M25 Junction 10 / A3 Wisley Interchange Improvement project

Planning Inspectorate reference: TR010030

The Examining Authority's Deadline 6

Comments from Ockham Parish Council re project update and proposed changes to the Scheme and DCO* that we have been advised will be submitted by HE to meet Deadline 6:

2.3 Proposed Construction Worksite on Former Wisley Airfield

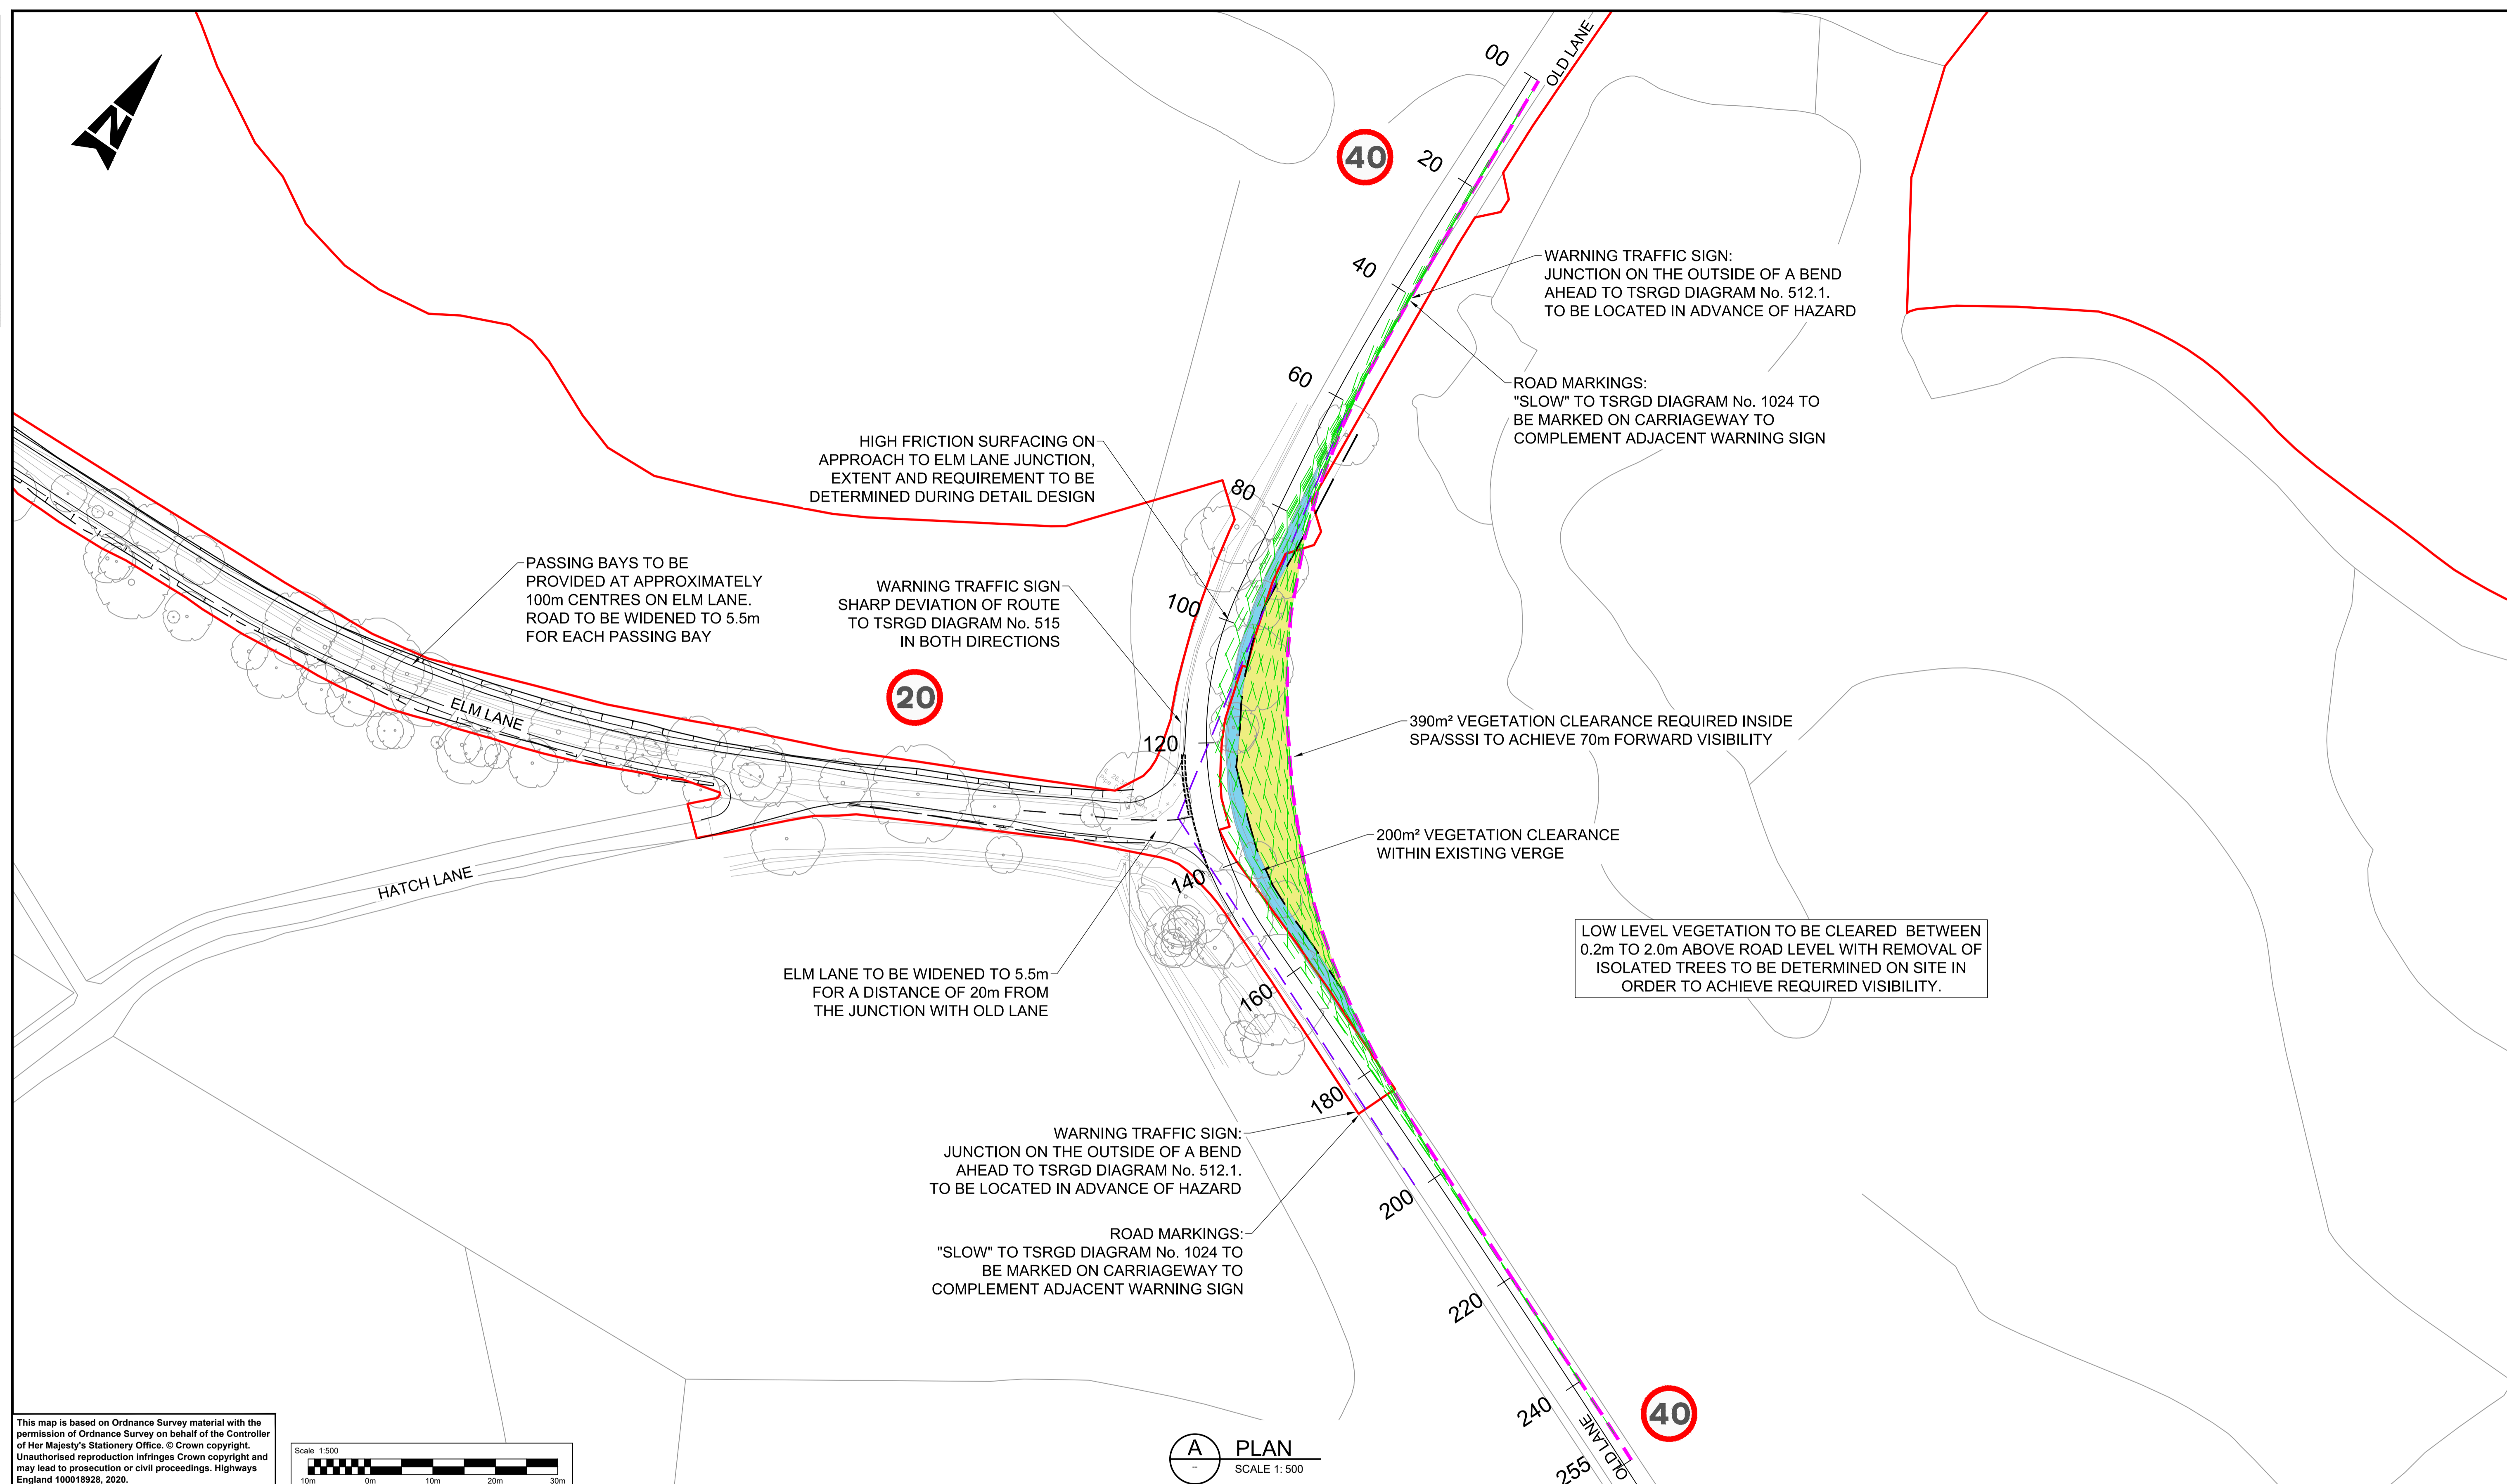
We note the provision of a minimum of 3 metre bund along the north eastern boundary which we welcome. Following discussion with HE on 03.04.20 we do believe that any bund provided should be significantly higher and incorporated with planting / acoustic fencing.

When we met at the site visit, we were assured that the area would be a minor site for storage only, this appears to no longer be the case with a significant amount of activity proposed. This will impact substantially on residents of Ockham, primarily those who live in the hamlet of Elm Corner.

We do not agree that as stated by HE, the environmental effects of the site as proposed would not have any material change to the effects already assessed. We refute this and have requested that HE provide us with the evidence to support this statement.

The letter states *infrequent materials processing activities*. Infrequent is an ambiguous statement and we have requested clarity on this. We also note that it is anticipated that this activity will be carried out *intermittently* for periods of around two to three weeks every few months but we draw no comfort from this statement which is similarly ambiguous.

We can see that drawing [HE551522-ATK-LDC-A3 L1-DR-ZL-096502-Rev 0.pdf](#) shows the earthworks material storage and processing is to be located at the furthest point from Elm Corner within the compound but that the equally pollutant structures storage area to include a worksite for construction, welding and assembly of steelwork will be positioned close to EC. This is completely unacceptable. Vibration from all these works will be significant as will dust and noise pollution.
